Planning Application Reference No.: 3/2025/0223

Address of Development: 21 Park Avenue, Clitheroe, BB7 2HP

Comments: Subject: Concerns about Proposed Extension

Drawing Title
Proposed Plans and Elevations for
Two Storey Side Extension

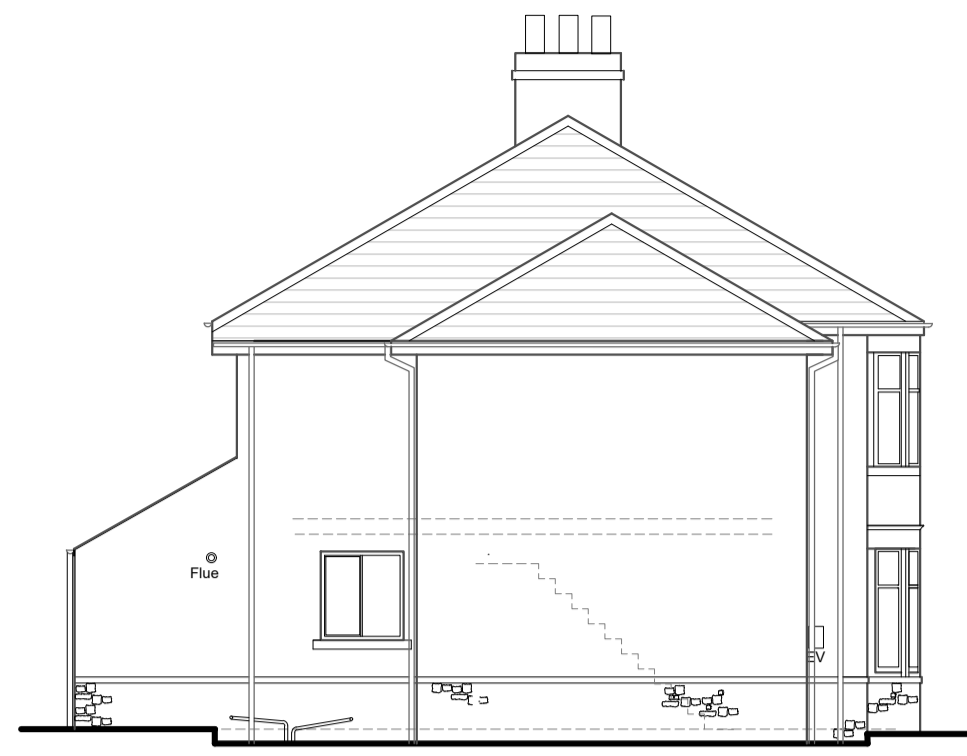
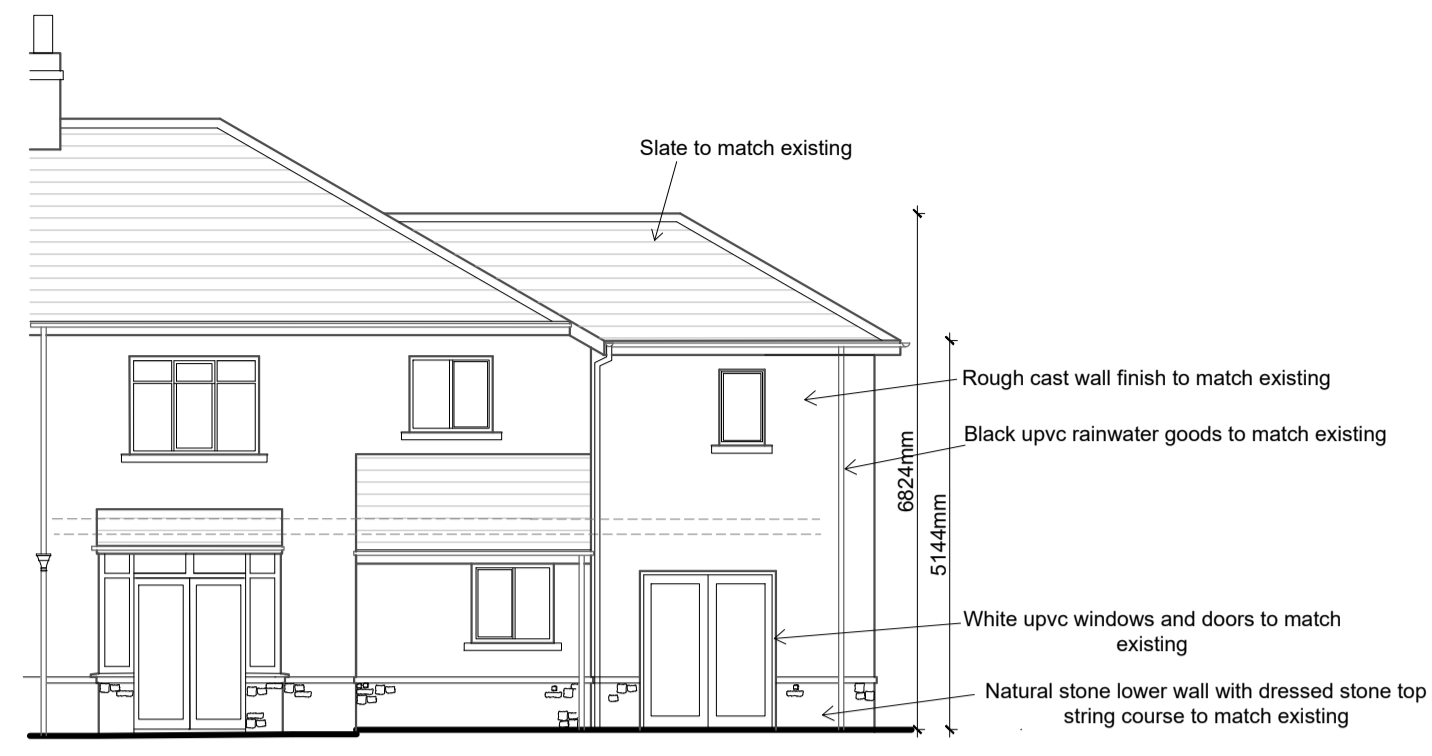
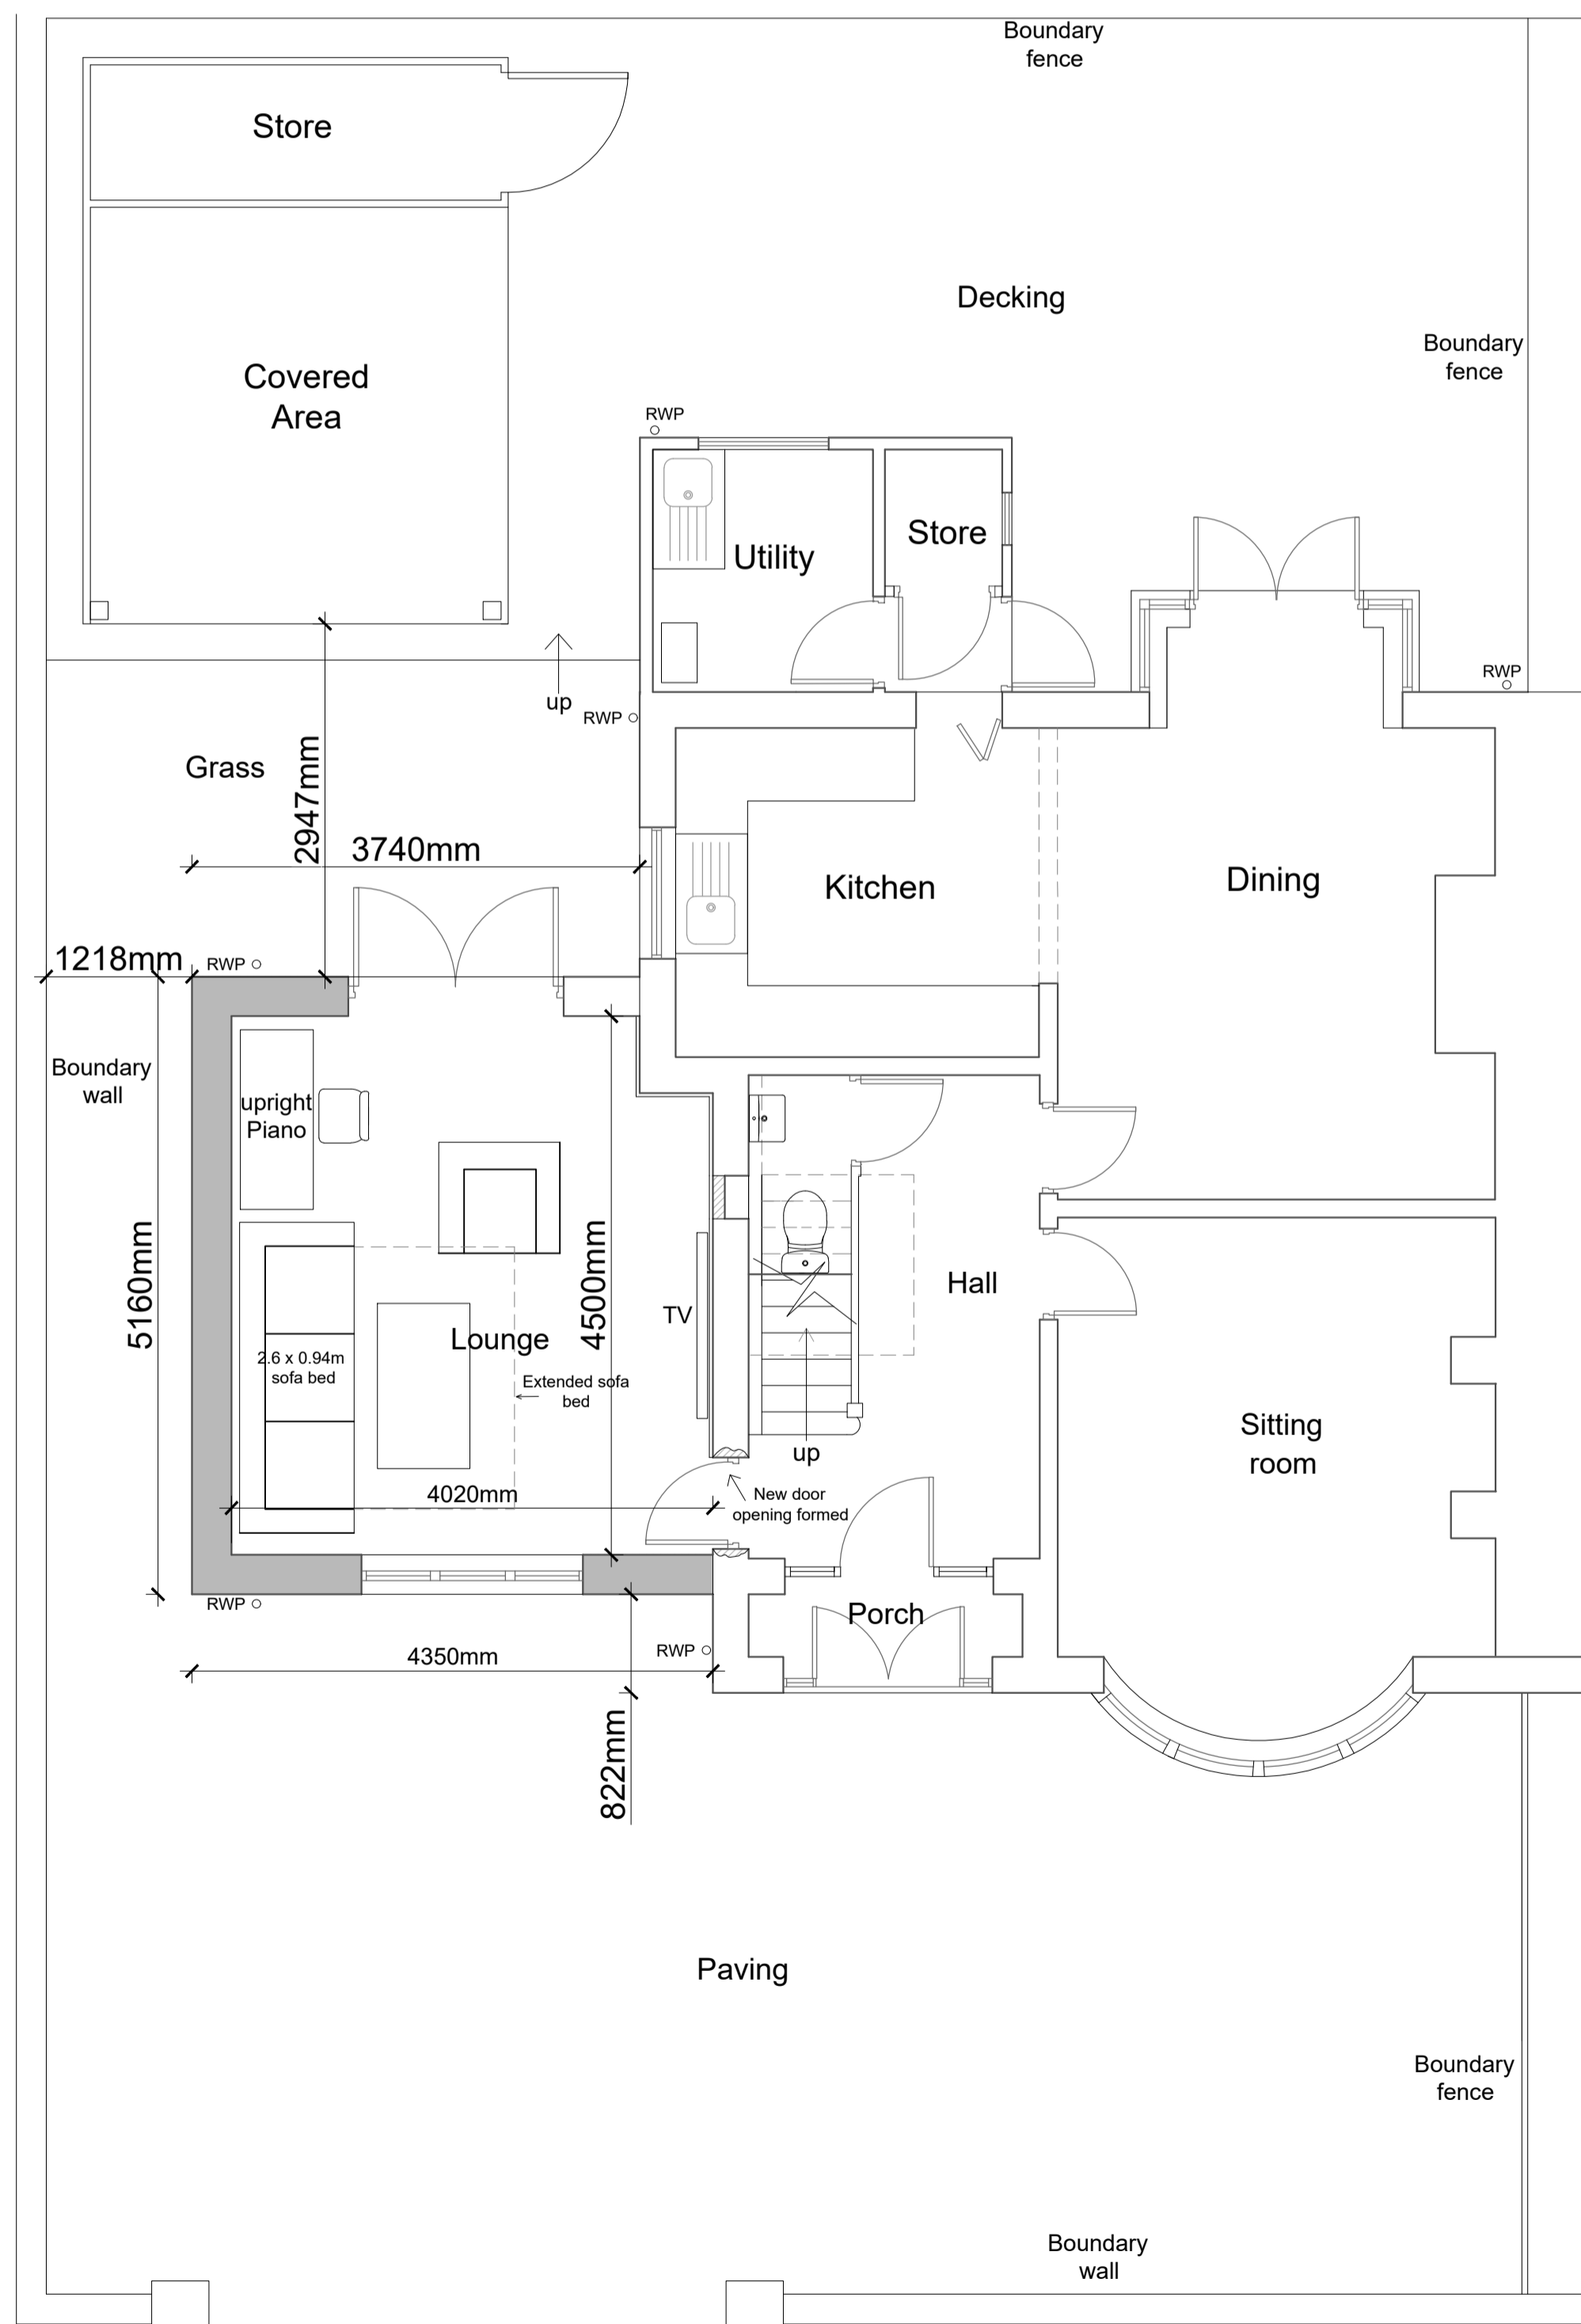
The [REDACTED] South-East facing and [REDACTED] e which is subject to this planning application. From [REDACTED] especially during the winter months when the sun is lower in the sky. [REDACTED], which are on the ground floor and rely heavily on this sunlight. The loss of light would really affect our [REDACTED]. We also [REDACTED] and we are [REDACTED] extension would affect the performance of these panels.

In addition, our property is [REDACTED], which means the proposed extension would feel particularly imposing. The increased height and bulk of the structure [REDACTED], creating a sense of enclosure that we're concerned would change the current feeling of openness we experience.

We hope that these concerns can be considered as part of the decision-making process, and we appreciate you taking the time to listen. From our point of view, if the proposed extension was single storey this [REDACTED].
